**CITY OF PORTLAND, MAINE
Portland Exposition Building Drainage Improvements
Bid #5709**

Current Date: March 12, 2009

NOTE: The following is a response to questions recently received on this bid:

2 LANDING AND RAMP PLAN
SCALE: 3/16":1'-0"

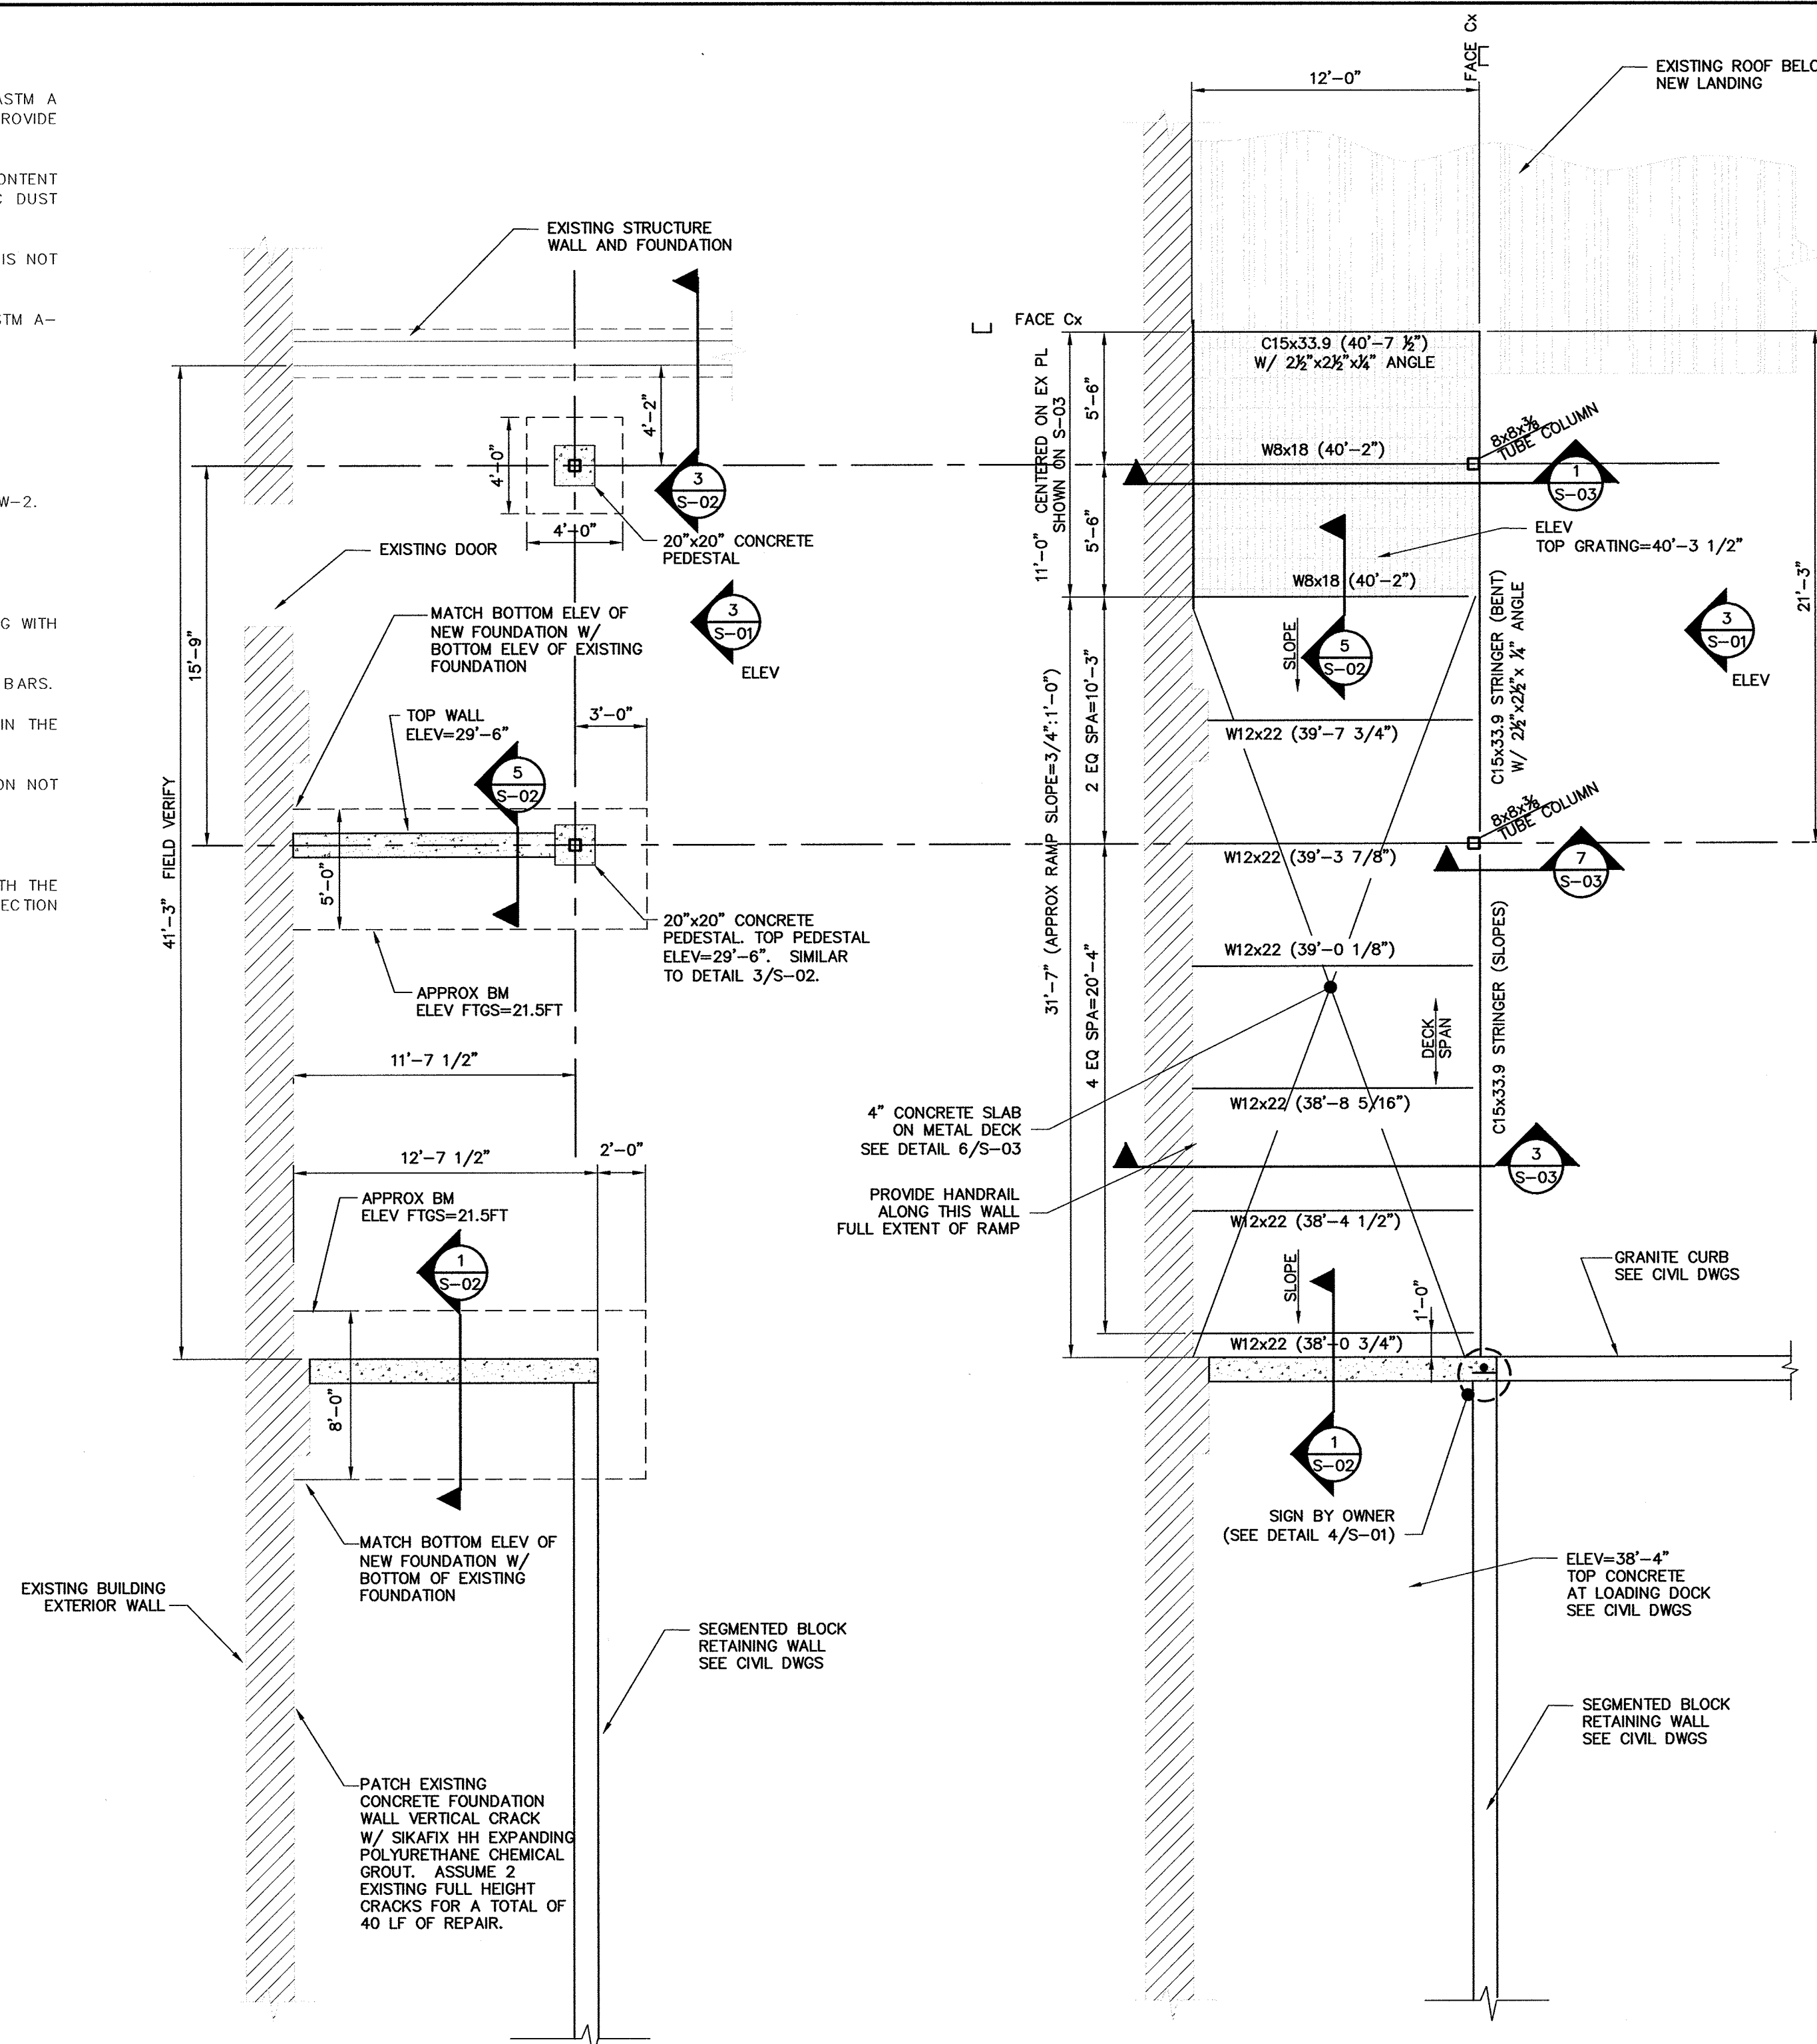
1. *On sheet S-01, detail 2, there is a note that states "Provide Handrail Along this Wall Full Extent of Ramp". Can the railing stop and start at the masonry column? Or does it need to be continuous?*

The railing must be continuous per the International Building Code 2006.
